**From:** Contact Centre (CRM) <contact@ribblevalley.gov.uk>  
**Sent:** 17 December 2023 16:55  
**To:** Planning  
**Subject:** Planning Application Comments - 3/2023/0903 FS-Case-570018056

**Planning Application Reference No.:** 3/2023/0903

**Address of Development:** 9 Moor Field, Whalley BB7 9SA

Proposed Rear Elevation (2)

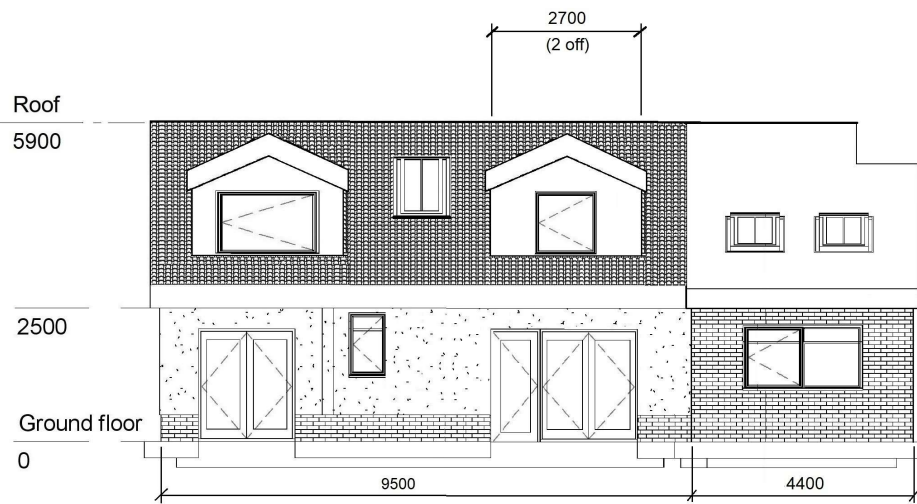
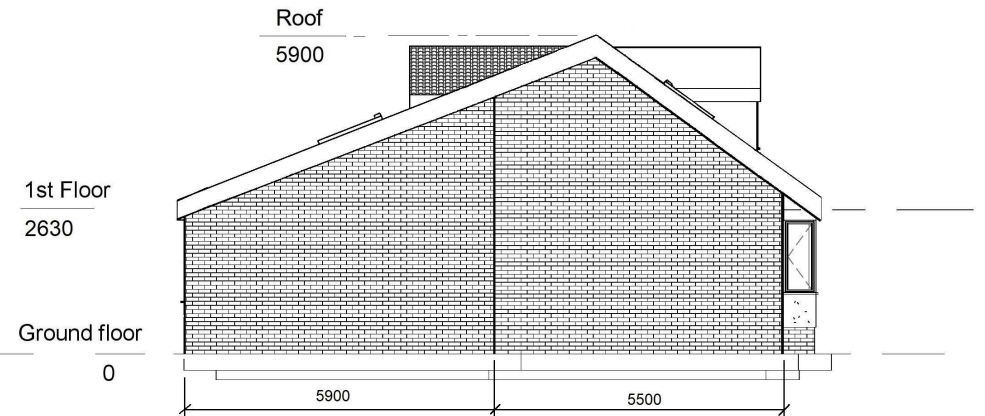
1. it increases the overlooking and loss of privacy to [REDACTED]
2. our concerns, which we believed to have been amicable addressed without objection, have been subsequently ignored by the applicant
3. the roof works and additional rooflights are already well progressed although planning permission has not been granted for the variation
4. the application states that we were consulted on 12/12/23 . We were not and, but for a chance check on the planning portal due to noise nuisance on a Sunday afternoon, would have been utterly unaware.
5. \*we wish to retrospectively raise a formal complaint regarding the earlier planning approval of application 3/2022/0130, the reason being it states in the findings:

We may withdraw this objection if, and only if, all glazing to the first floor rear elevation are fitted with obscure glass as was the case with the original property. This would allow the development to continue, albeit without permission granted as yet, per the latest planning amendment, providing the fully extended space and design with little or no impact on the applicant.
